Re: Renovation to Existing Building
1844 Forest Avenue
Portland, Maine

Project Number: 11-071B

STAGE FRAMING PLAN (RAISED)

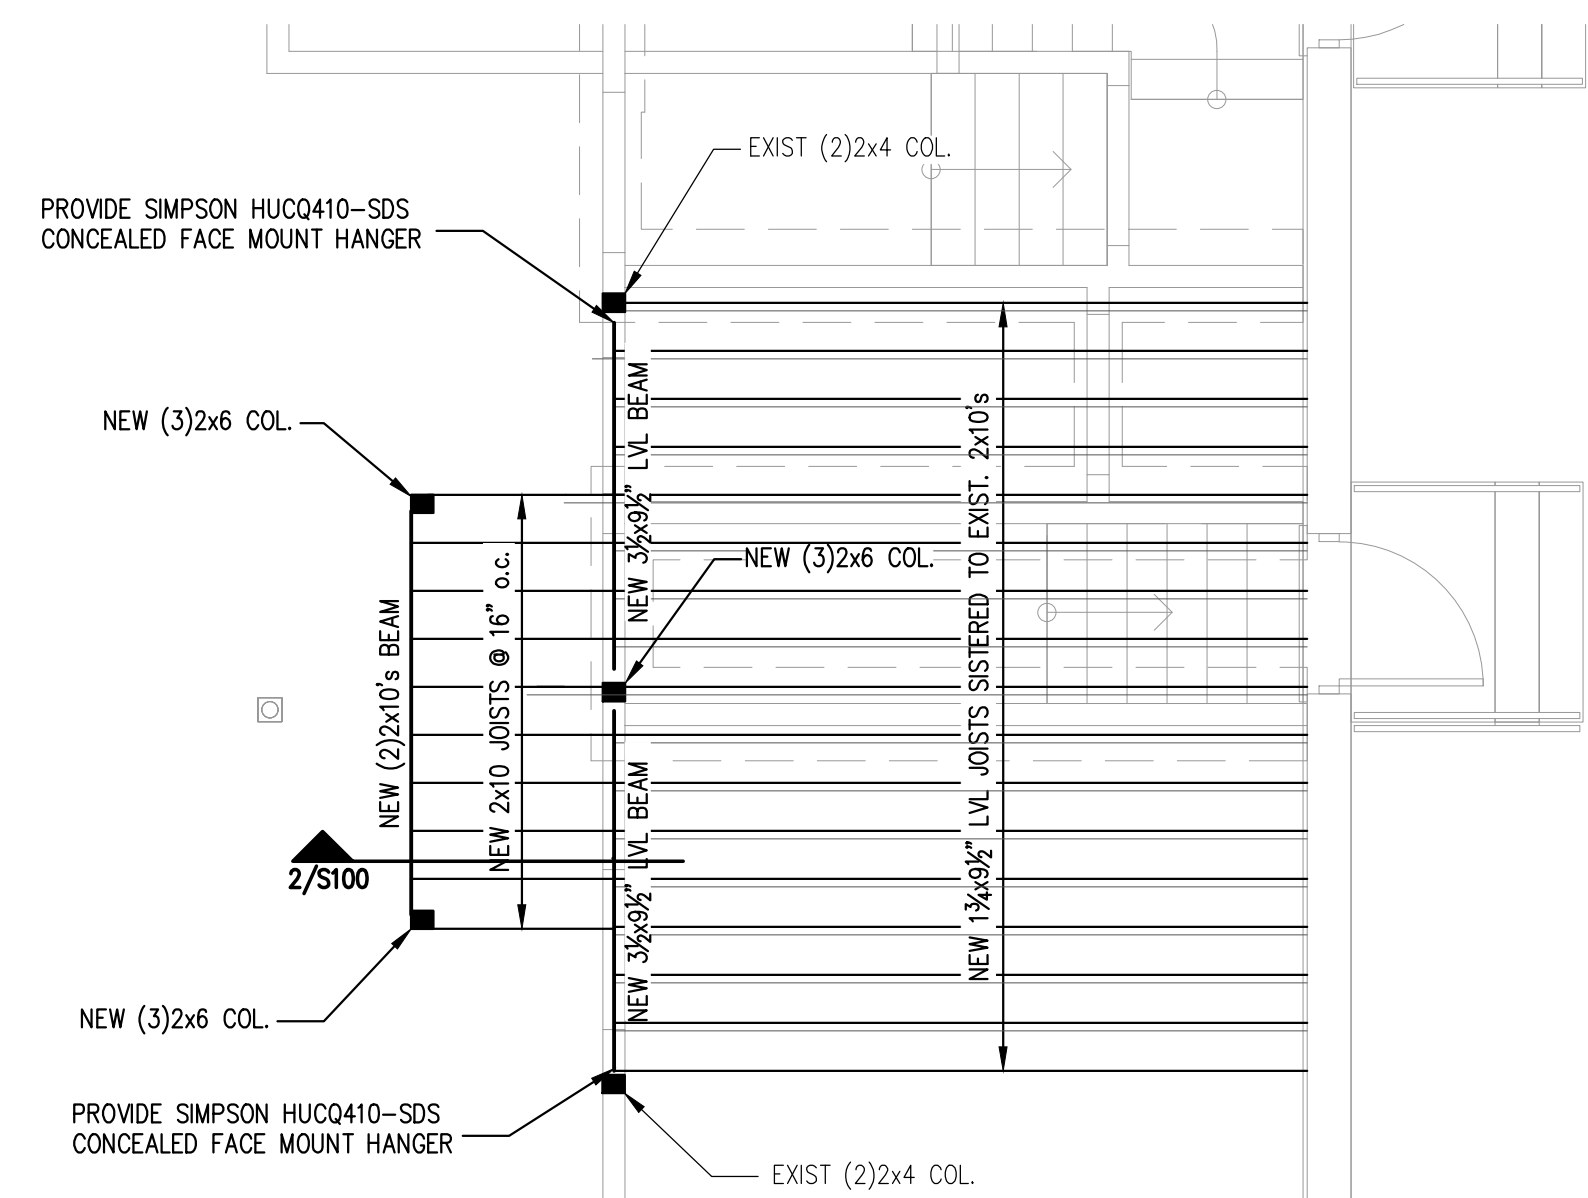
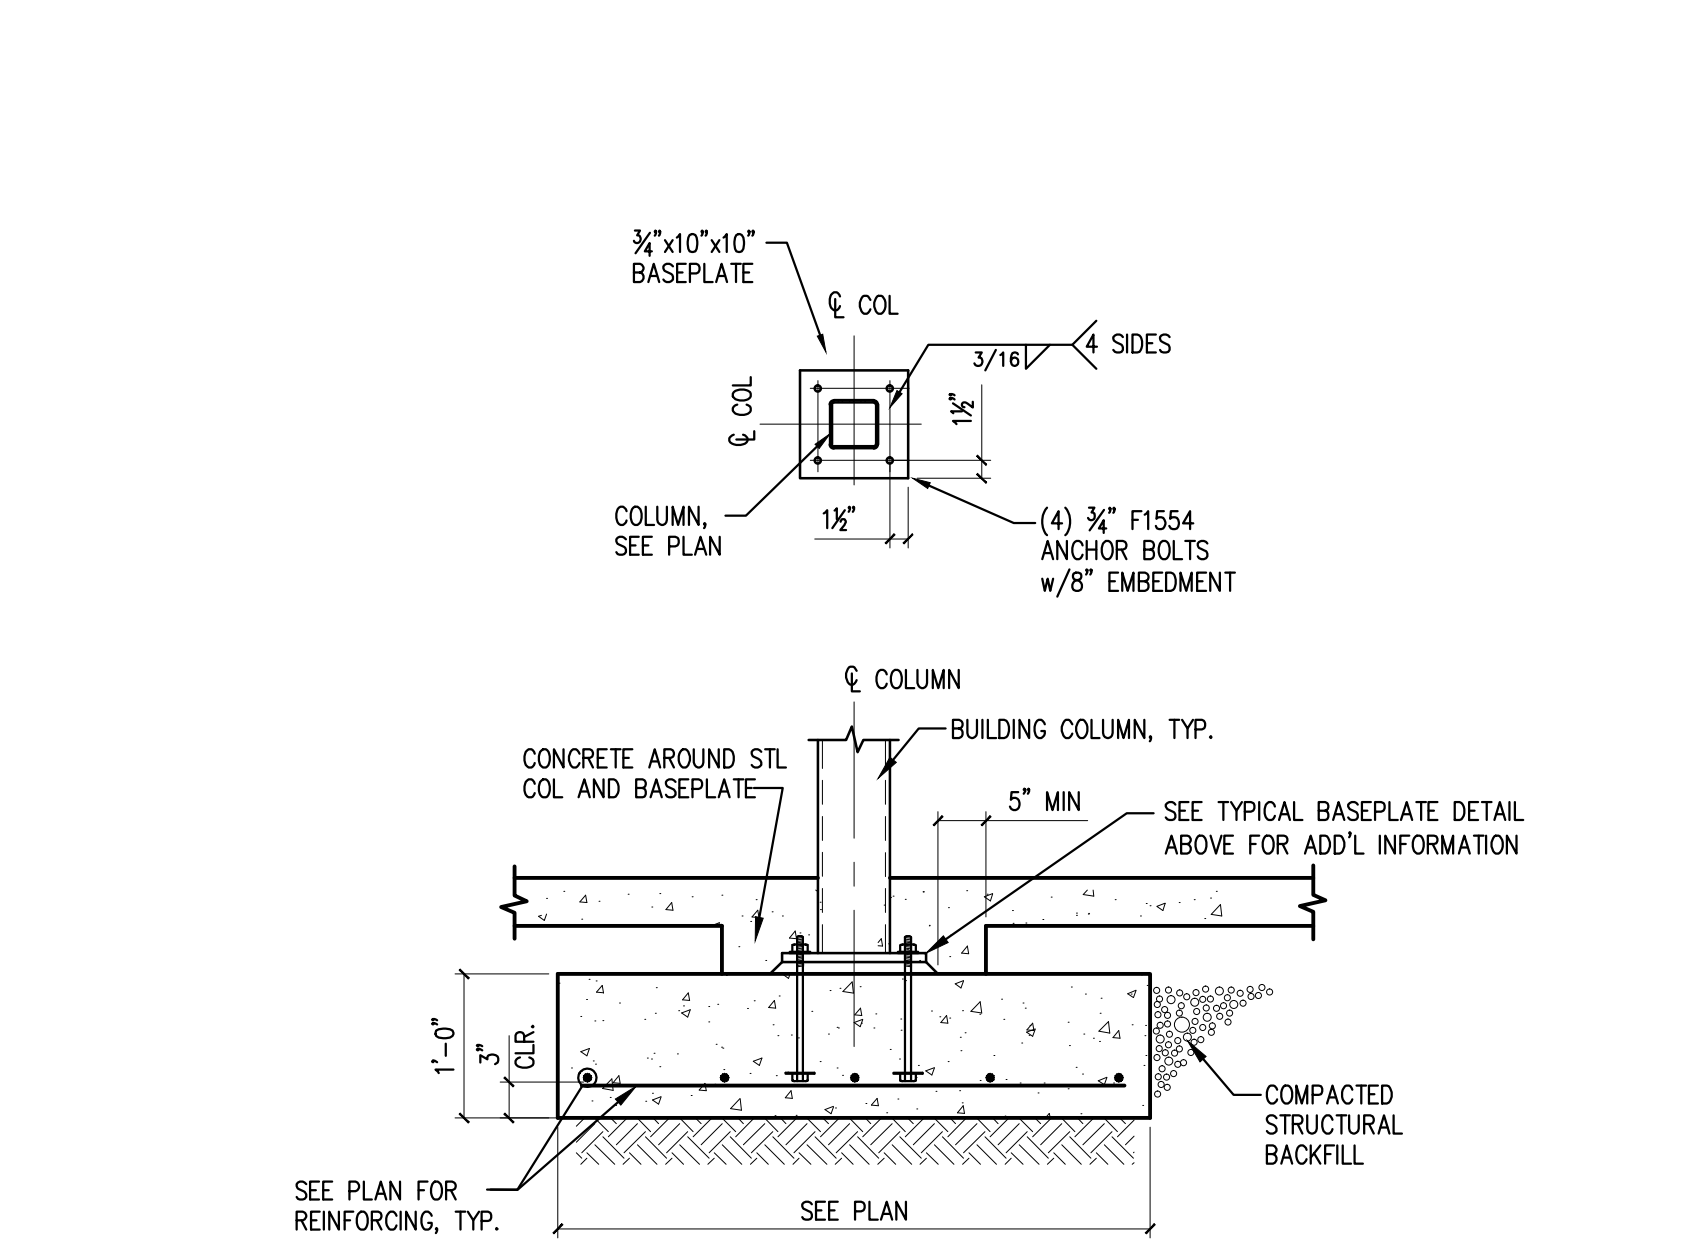
Casco Bay Engineering has analyzed the loading for the stage framing and under stage storage framing and determined that the joist hangers specified on the contract documents can be attached using #8 wood screws in lieu of 10d nails.
